Recommendation Report for Planning Permission for Works or Extension to a Dwelling

REF NO: LU/250/19/HH

LOCATION: 40 Parkside Avenue
Littlehampton
BN17 6BQ

PROPOSAL: Single storey rear extension and two storey side extension

DRAWING TITLE
PROPOSED FLOOR PLANS / PART
SITE LAYOUT

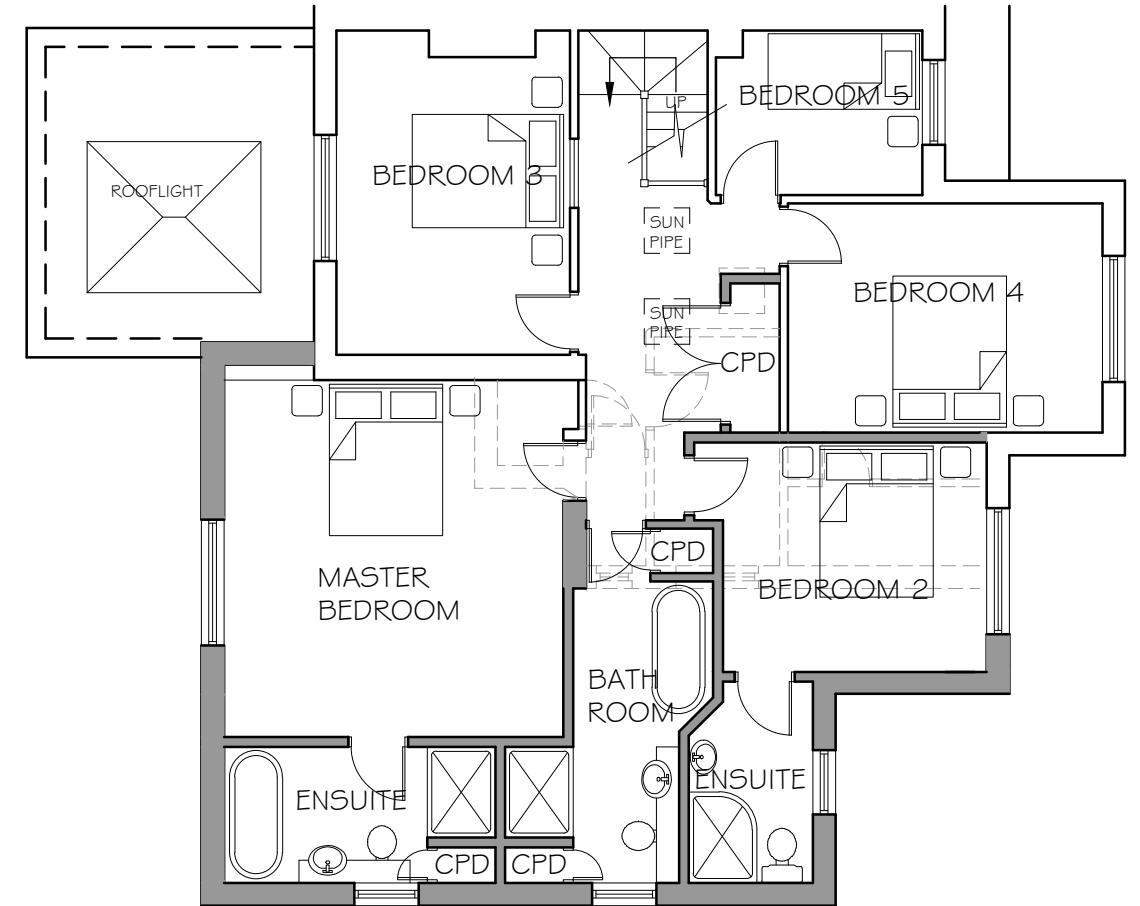
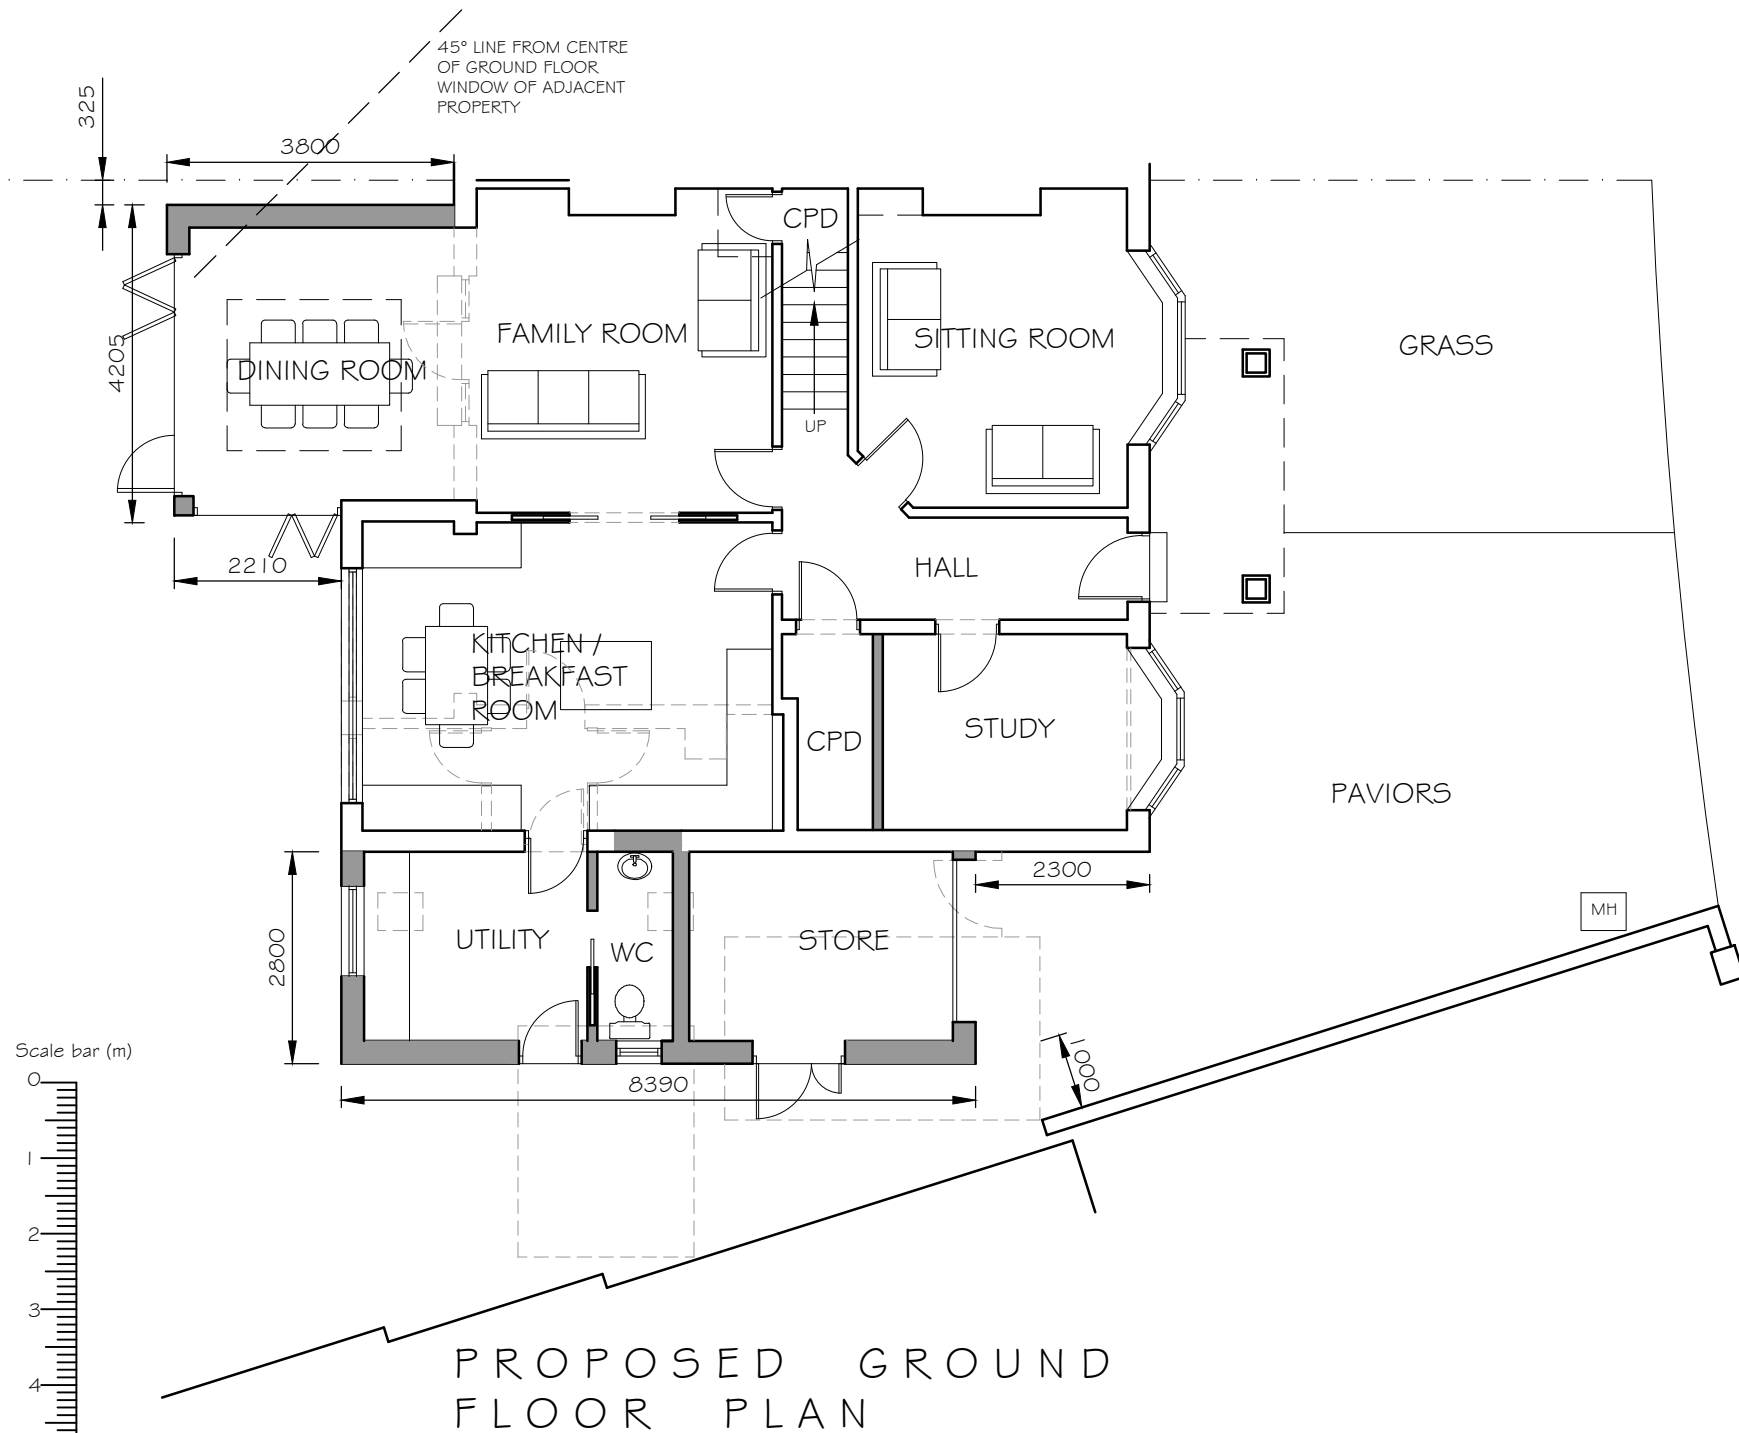
The proposed extension is not considered to give rise to any significantly adverse impact on the neighbouring dwellings. The impact of overlooking from the rear is no worse than that from the existing dwelling and with the length of the garden any overlooking to the rear is mitigated. There is a proposed sky light on the single storey rear extension that is not considered to gain any views that would cause for a loss of privacy to the neighbouring properties due to location. The windows on the first floor of the Southern elevation face the neighbouring property and as such could be deemed to overlook. To avoid this issue the windows will be obscure glazed and fixed shut through the use of a condition. As such, the proposed development is considered to be in accordance with D DM1(3) and D DM4(c) of the Arun Local Plan.

DRAWING TITLE
PROPOSED ELEVATIONS

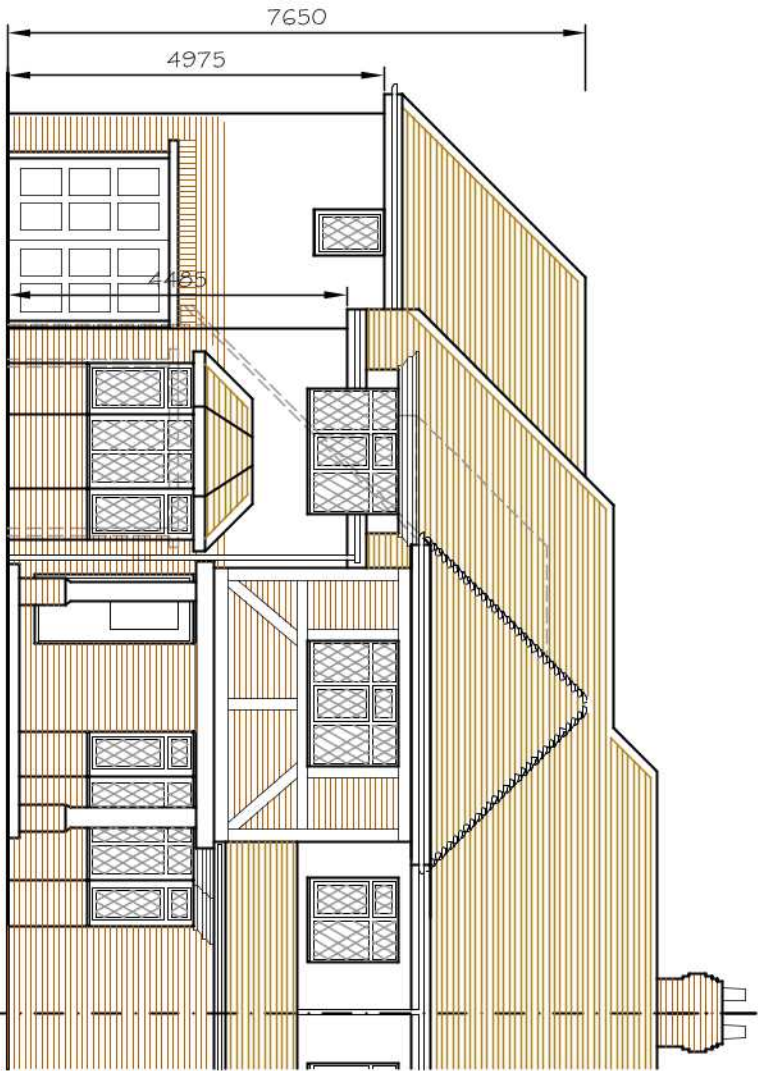
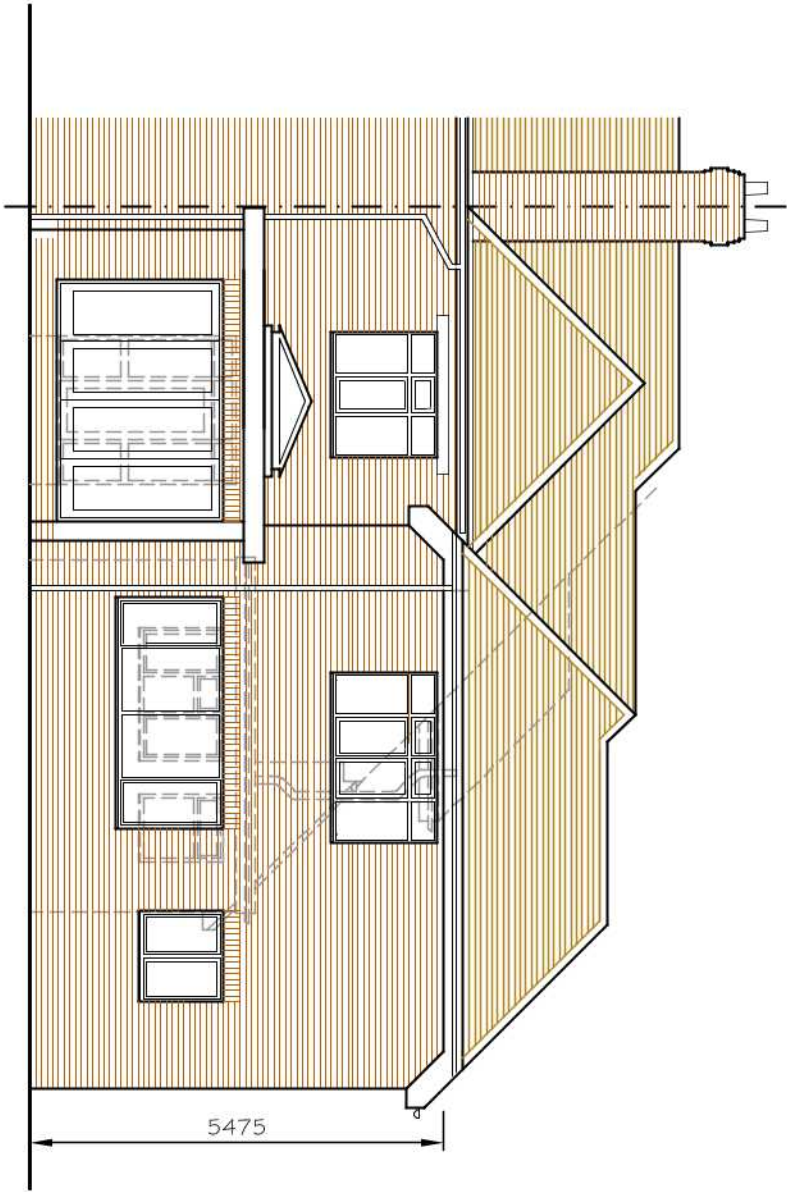
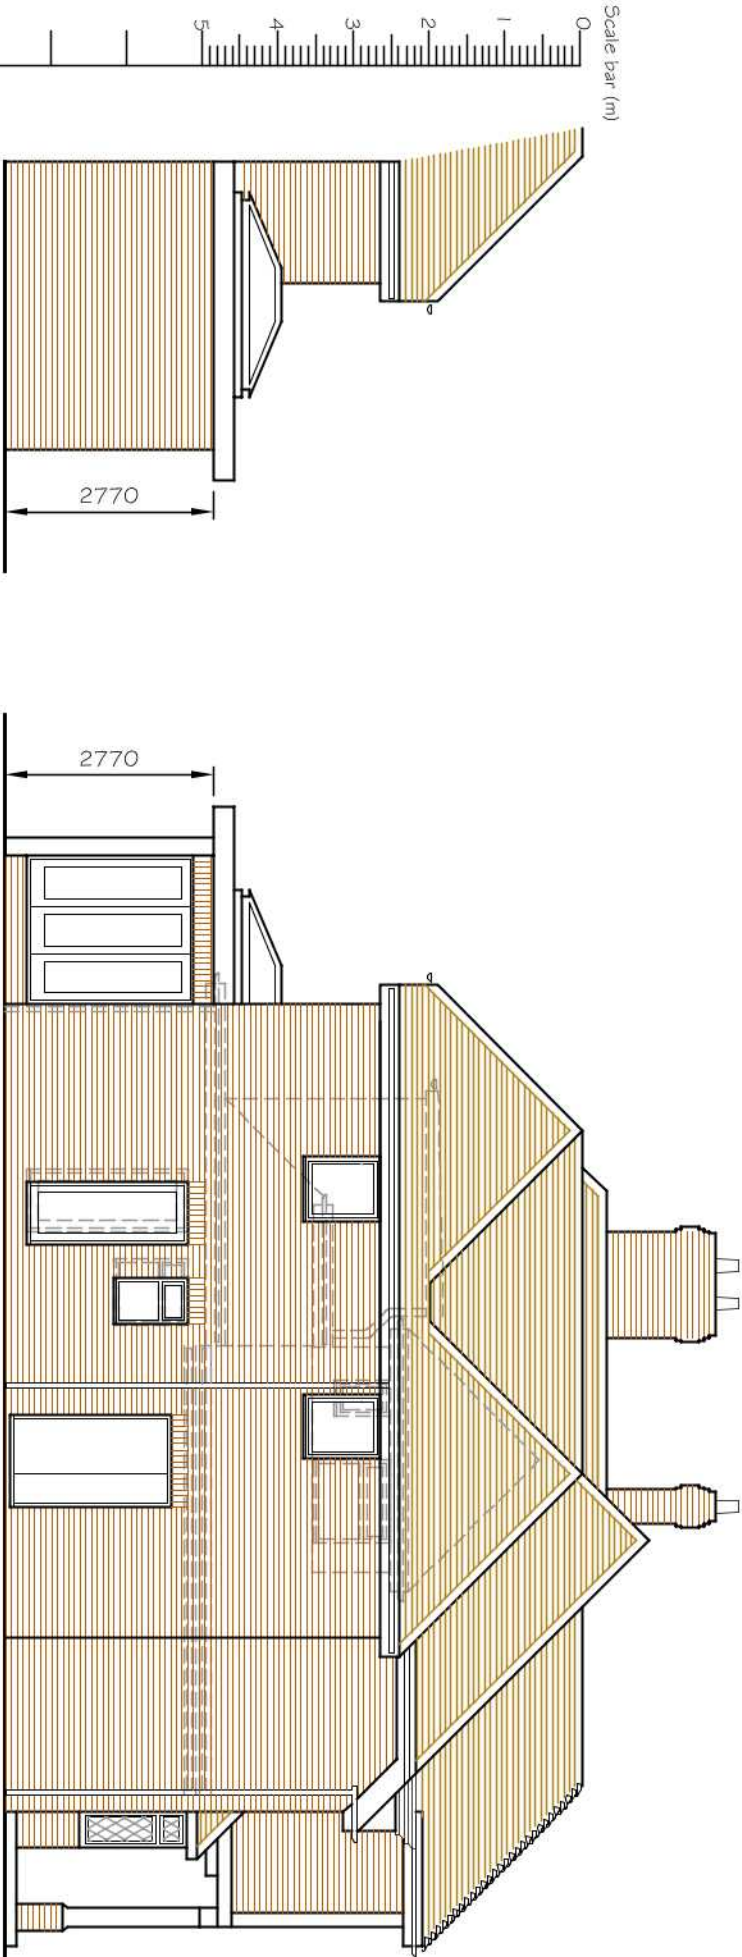
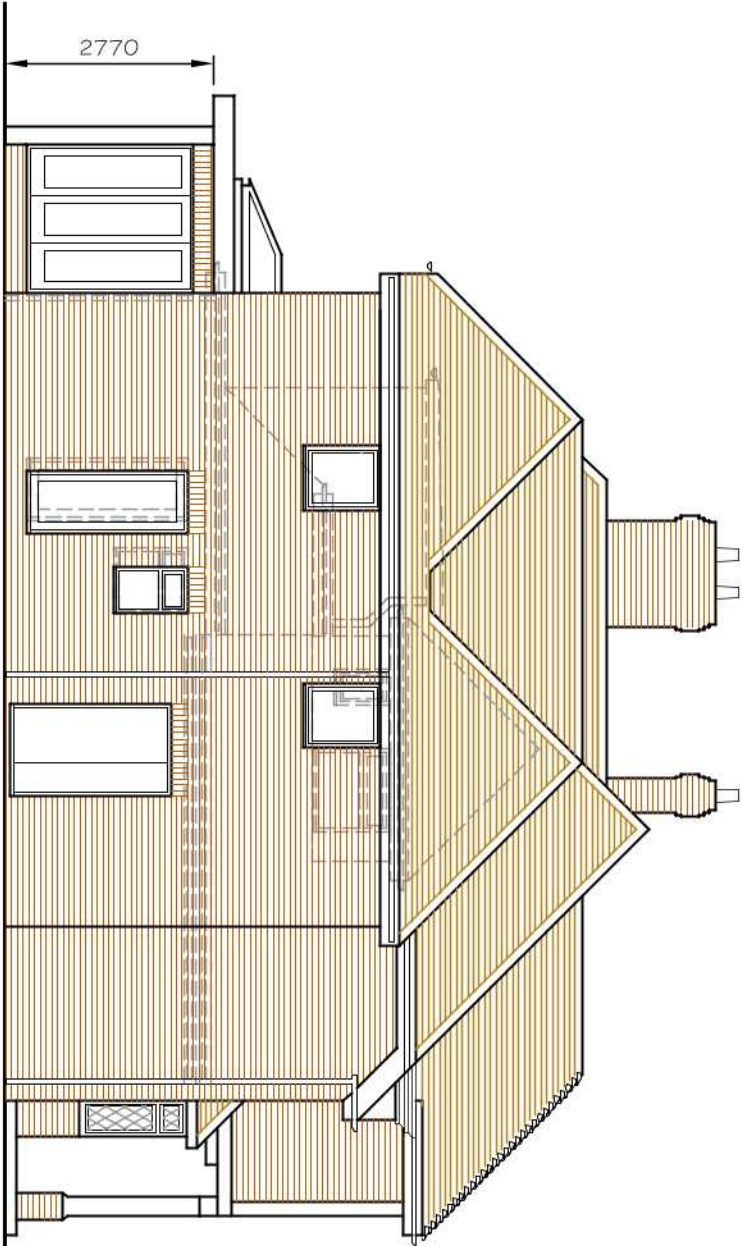
The proposed development is considered to result in a change of appearance of the host dwelling, as a result of the scale of the proposed side extension. However, it is not considered to have a significantly detrimental impact on the established character of the host dwelling as a result of its design and use of materials. The extension is considered to be a subservient addition to the dwelling as a result of its scale and it appears to be visually integrated with the existing dwelling. This is because it has a ridge height lower than that of the host dwelling. Therefore, the proposed extensions are considered to be in accordance with D DM1, D DM4(a) and (b) of the Arun Local Plan.

The proposed side extension is readily visible from the street scene, resultant of its location. However, given the angle, and dimensions of the extension it is considered that as a result of the appearance of the properties in the locality, and the integration of the extension into the host dwelling, the development is not considered to be visually harmful to the established character of the area or the property. The area does not have a uniform spatial character as a result of similar extensions. As a result of this, the proposal is deemed to be in accordance with D DM1 and D DM4 of the Arun Local Plan.

- 3 The windows at first floor level in the Southern elevation of the building shall at all times be and remain fixed shut and glazed entirely with obscure glass below 1.7m from the finished ground floor level.
